From: Planning
Sent: 14 October 2021 12:14
To: Planning
Subject: REDACT AND UPLOAD Planning Application No: 3/2021/0880

From: [REDACTED]
Sent: 14 October 2021 12:13
To: Planning <planning@ribblevalley.gov.uk>
Subject: Planning Application No: 3/2021/0880

I am writing in regards to the above planning application that has been made to the council for 2 (only) Camping Pods. Whilst I am not against the application, I would like to raise a couple of concerns which are as follows:

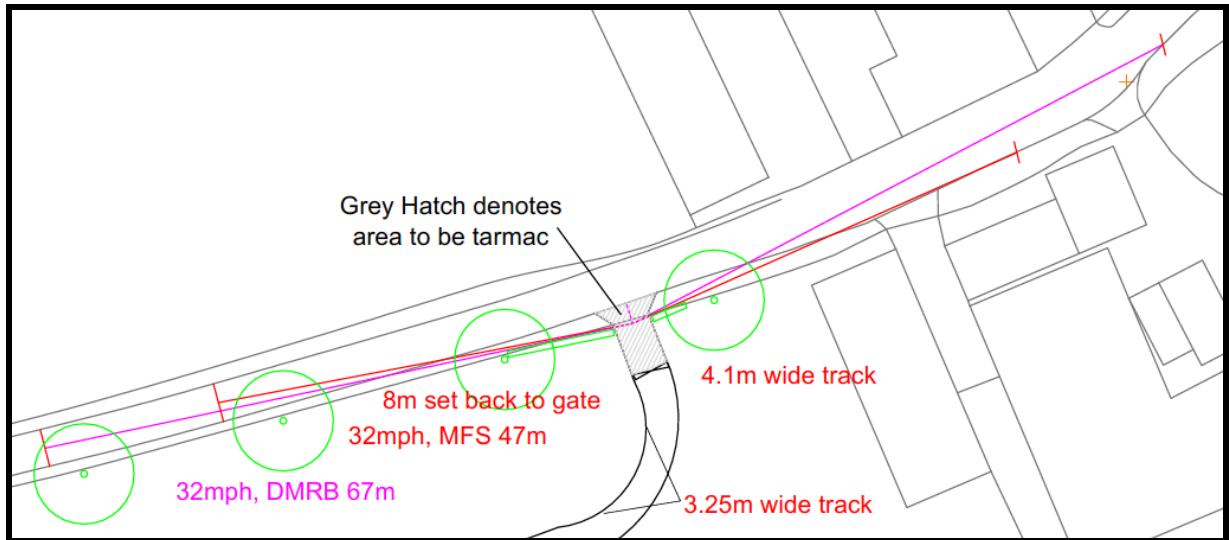
1) Safety - the lane at the suggested site entrance reaches its narrowest point of width, resulting in there only being access for one vehicle at a time to pass this location, and it has no passing points on this stretch. Therefore, resulting in a vehicle having to reverse out of the location if two enter at the same time. The lane is also frequently used by Large and Heavy Farming Machinery, motorbikes, walkers, horses and a team of cyclists - that can only pass this point one at a time, Most of them often pass at a speed that is questionable on this narrow restricted point of the lane.

As the hedge is at a considerable height - c. 3M, and depth, having an entrance located at this position can result in putting the Lane users' safety at risk. Consideration needs to be given to the safety of both those using the lane, and those using the proposed new entrance, due to the restricted visibility that both parties will have when entering this area. In addition, the corners of the entrance add further visibility restriction due to them being covered by mature Oak Trees.

In order to respect the safety of all people / vehicles entering into this area, the entrance must have adequate visibility to ensure vehicles do not need to edge out to see if the lane is clear, and the lane users can see any vehicle trying to enter onto the lane. This would help in reducing the risk of a potential accident at the entrance, or caused due to the restricted visibility at the entrance's location. An option could be to widen the lane on the opposite side, thus providing an area for a vehicle etc... to deviate, or move into if required.
